**KIRKLEES METROPOLITAN COUNCIL
INVESTMENT & REGENERATION SERVICE**

DELEGATED DECISION TO DETERMINE PLANNING APPLICATIONS

Reference No:	2025/62/92913/W
Site Address:	393, Bradford Road, Fartown, Huddersfield, HD2 2QY
Description:	Change of use of dwelling (Use Class C3) for provision of education hall or meeting place for the principal use of the local community (Use Class F1) including erection of open sided structure to rear
Recommending Officer:	Elenya Jackson

Officer Report.

Ground Floor Layout 1:50

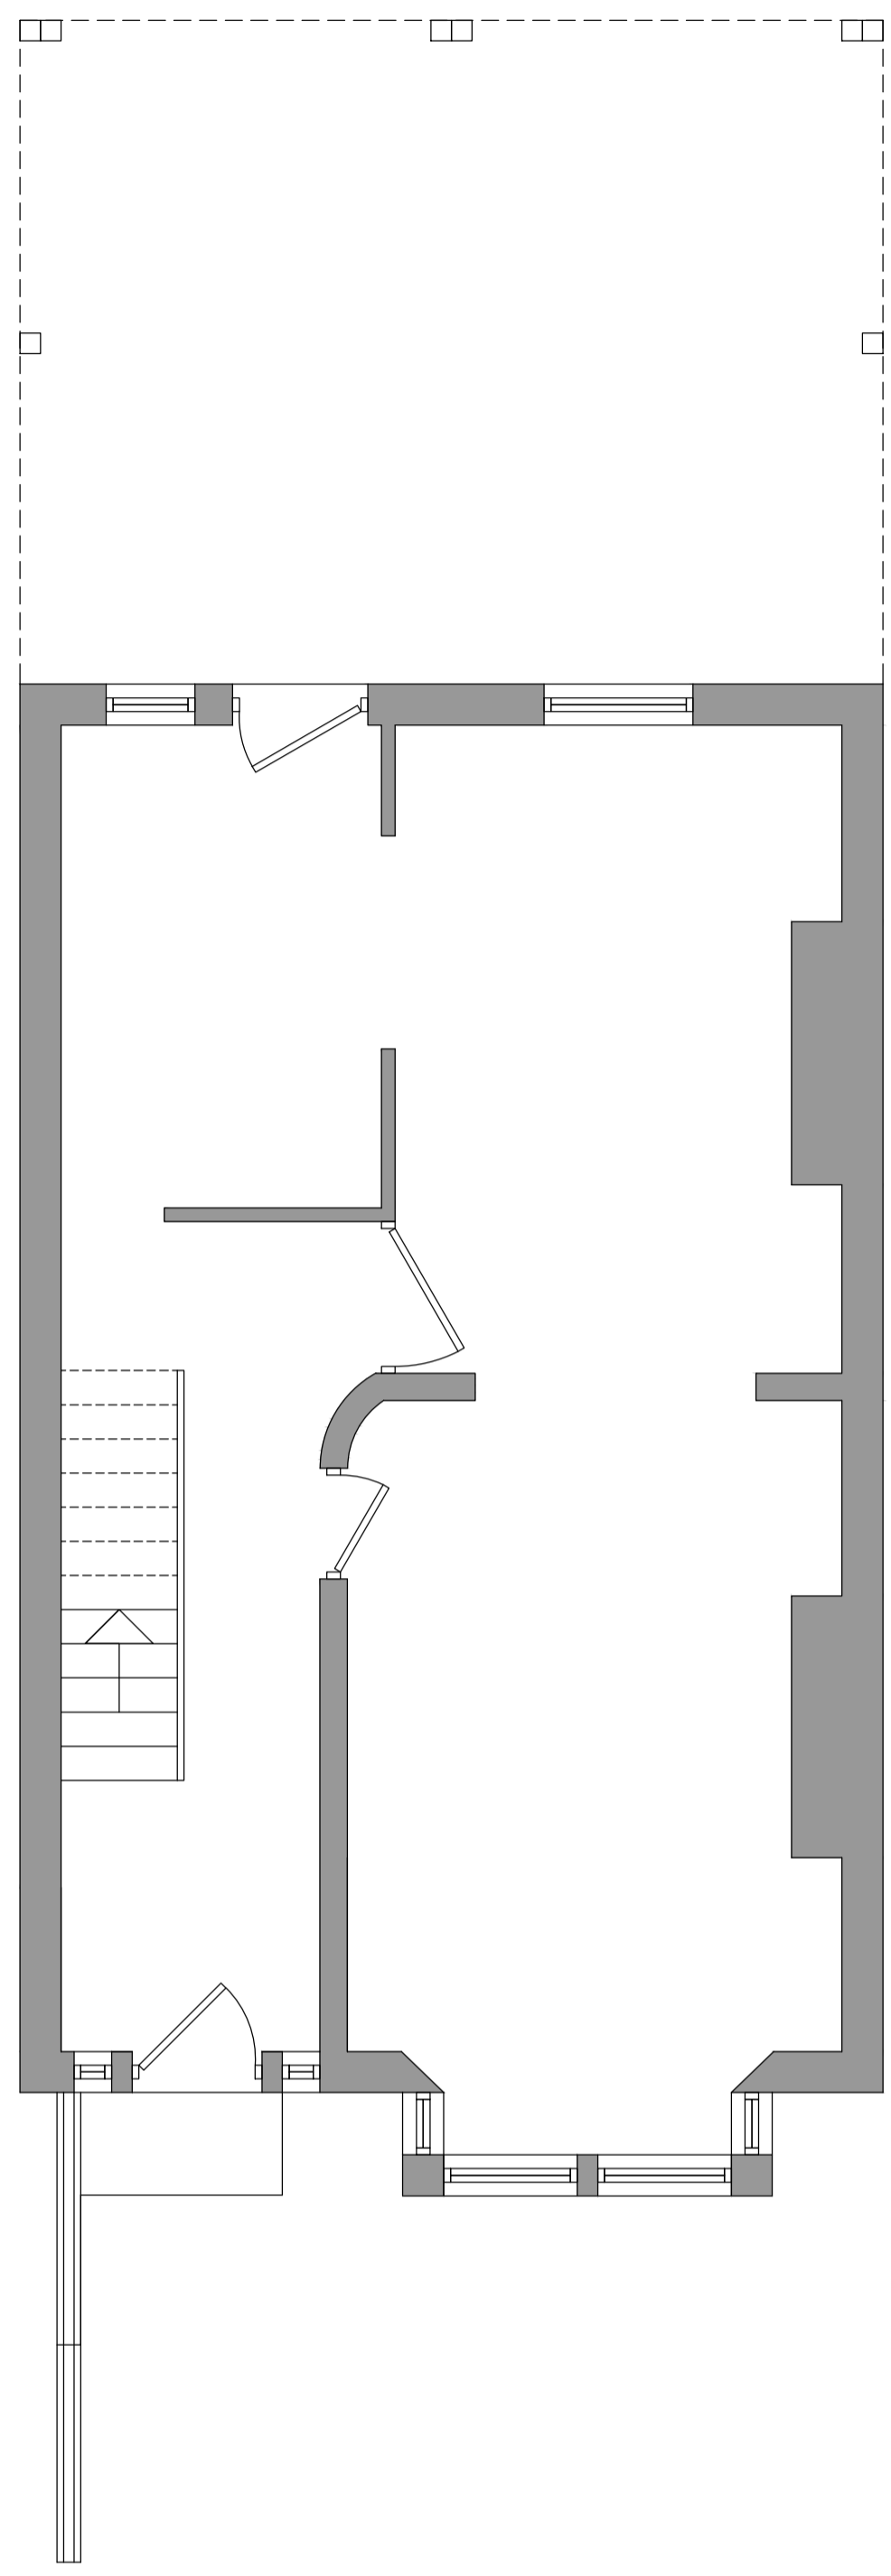
The proposal would also include erection of a single storey rear extension which would extend 4.8m and have a width 6.4m and a maximum height of 4m.

The proposal would feature a single storey projection at the rear of the dwelling which would not be visible from the public realm.

The depth of the proposal would be 4.8m; however, it is considered that the application site would retain ample amenity space should the proposal receive permission.

Overshadowing/loss of light/overbearing: The proposal would project 4.8m beyond the rear elevation of the existing; however, it is considered that the proposal would be located to the north of 391, have open sides and be single storey and therefore no significant issues would be raised regarding overshadowing/loss of light/overbearing.

The Planning Statement refers to a 'single-storey open-sided structure' but no detail has been given on the use of the external amenity area and this has not been considered in the NIA. Objections have been raised on the congregating of individuals which may lead to a loss of amenity.
